**Re: Office/Warehouse @ 3831 Masthead St NE  
Erosion and Sediment Control Plan  
Engineer's Stamp Date 4/17/23 (D17E095A)**

Based upon the information provided in your submittal received 4/17/2023, the above-referenced ESC Plan cannot be approved until the following additional information is provided.

ENGINEER'S SEAL RONALD R. BOHANNAN NEW MEXICO PROFESSIONAL ENGINEER 7868 4-17-23 RONALD R. BOHANNAN P.E. #7868	3831 MASTHEAD ST ALBUQUERQUE, NM	DRAWN BY pm
EROSION CONTROL PLAN		DATE 4-17-23
		DRAWING
		SHEET # SW-1
		JOB # 2022002

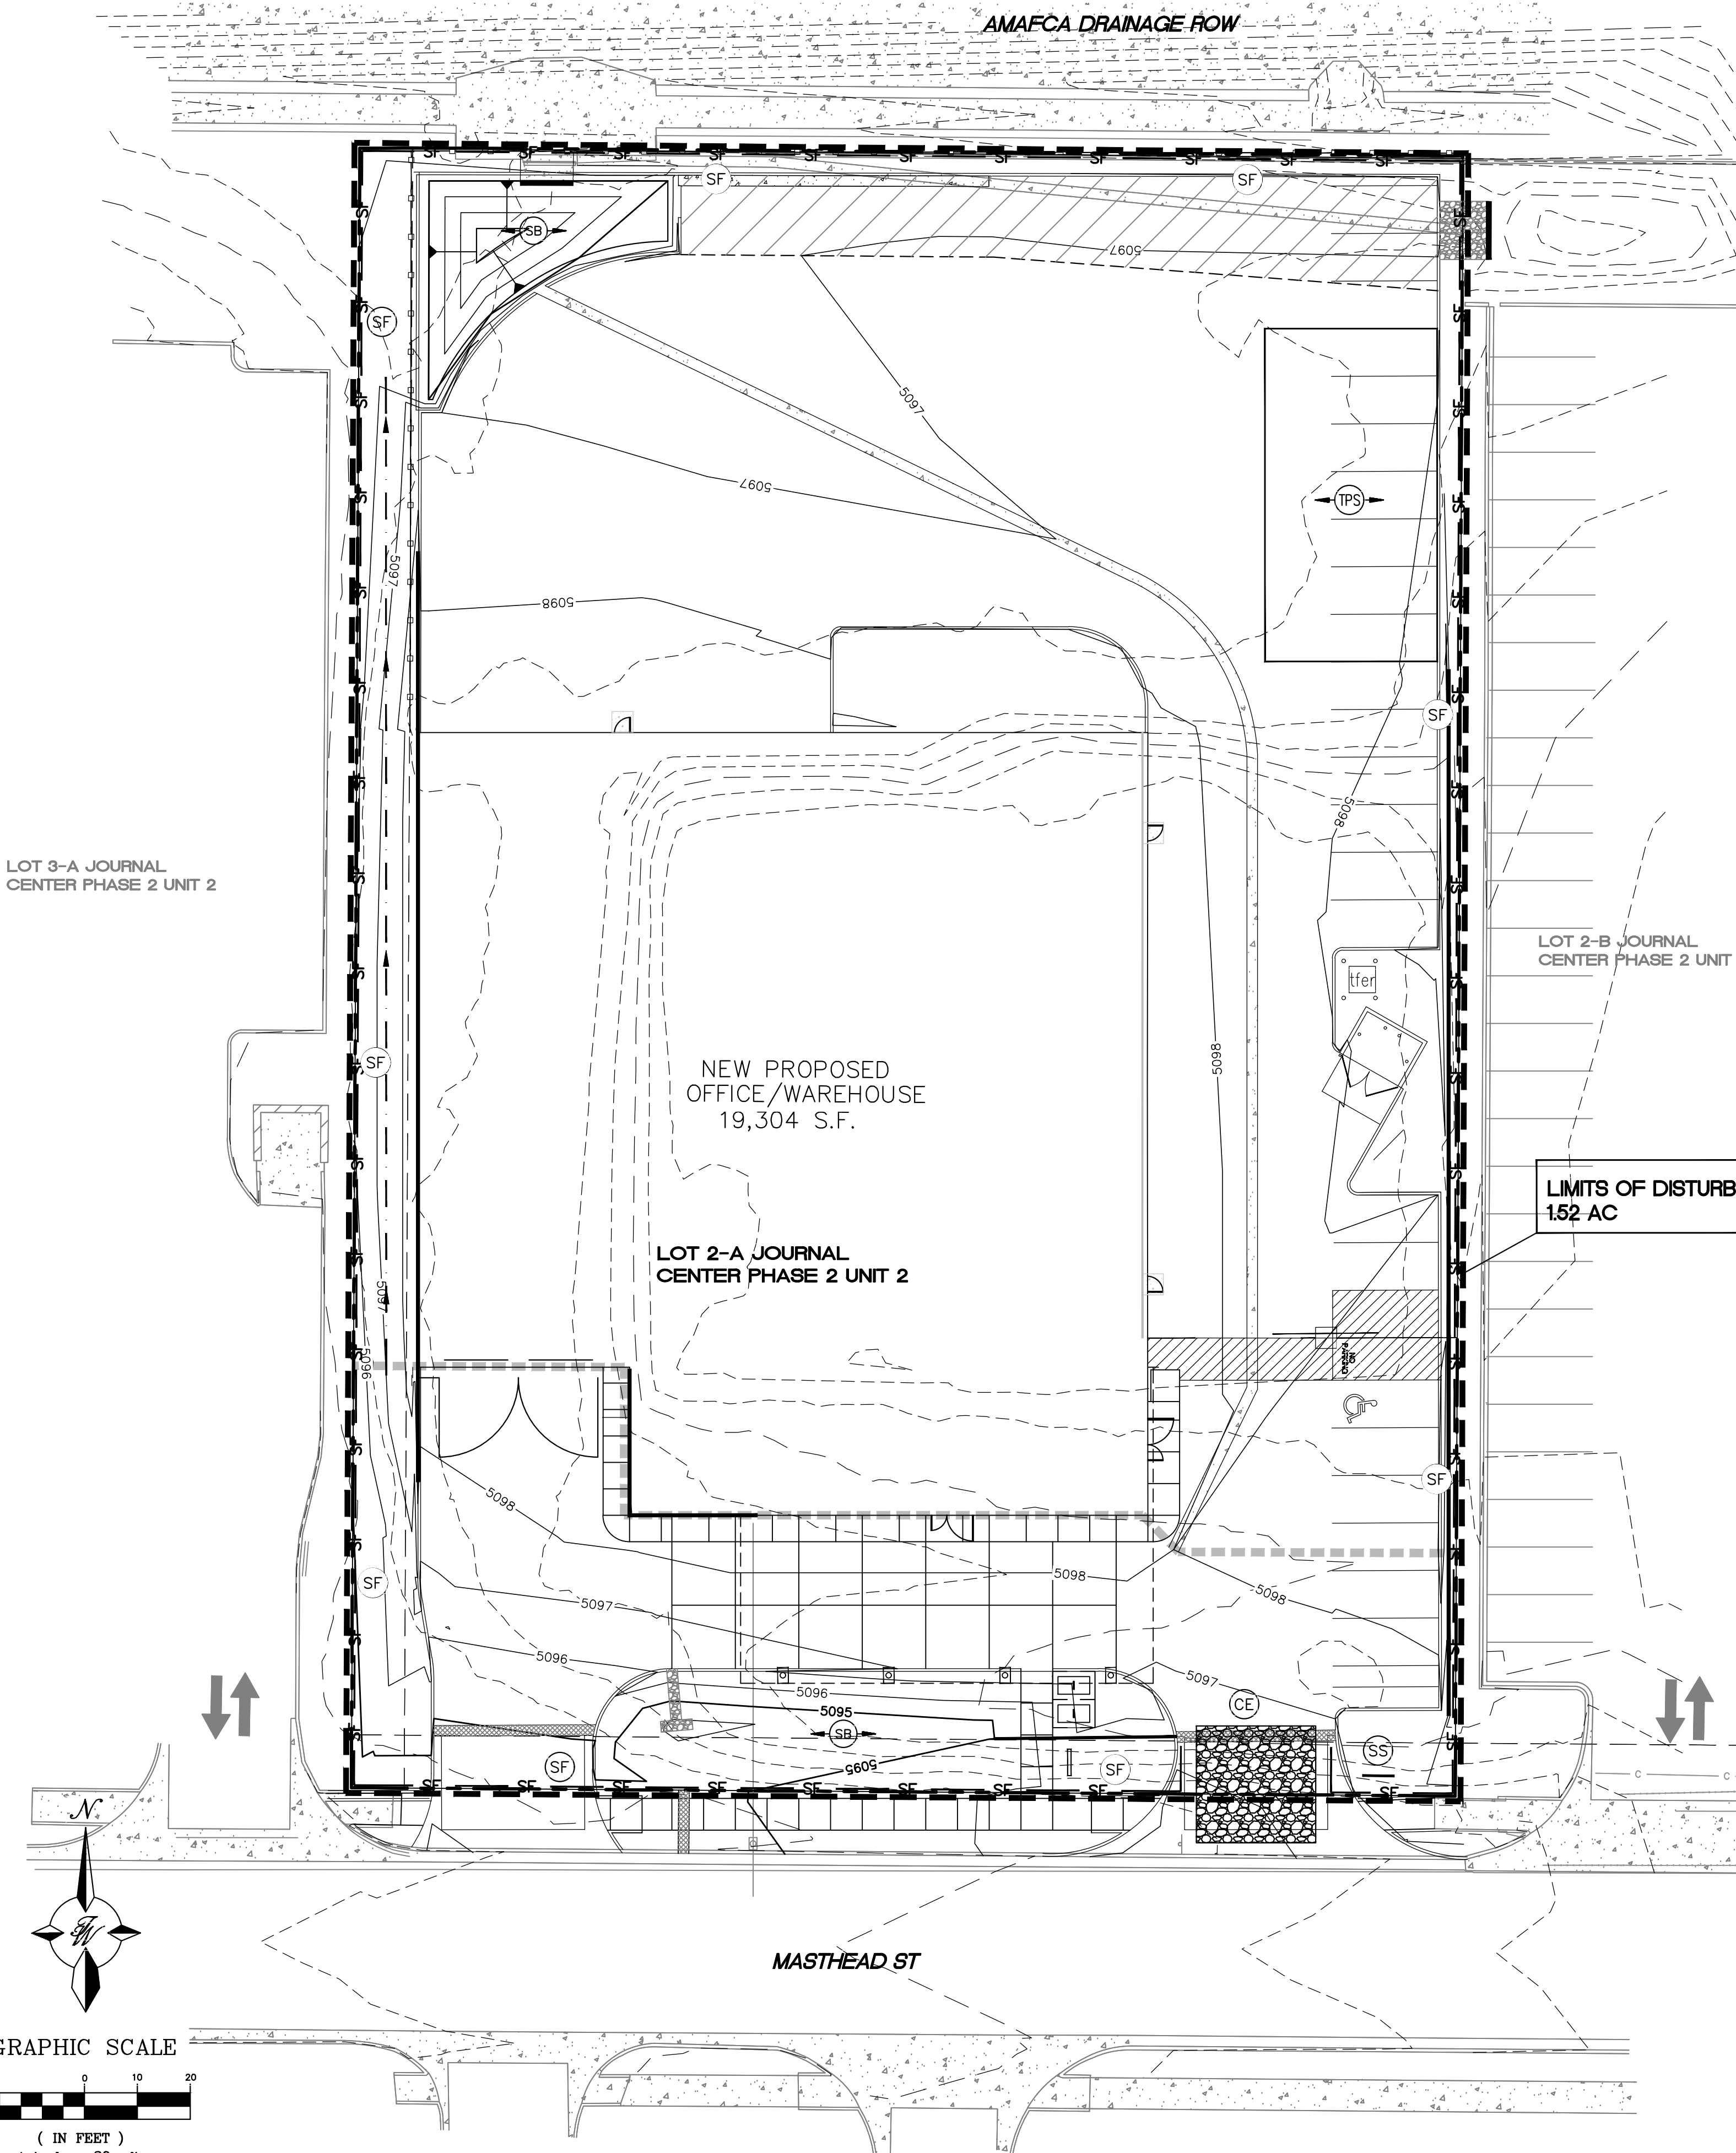
1. The ESC Plan can't be approved for Building Permit until the property owner's NOI has been reviewed and approved by City Stormwater Quality per Albuquerque Code § 14-5-2-11(a)
2. The SWPPP must include site-specific interim and permanent stabilization per CGP 9.4.1.c.i. The Landscape Plan can be used to satisfy this requirement and should be submitted separate from the ESC Plan with the application to the Stormwater Quality Section of the Planning Department and it should be included in the SWPPP. Provide a specification on the ESC Plan for any disturbed areas not covered by the Landscape Plan.
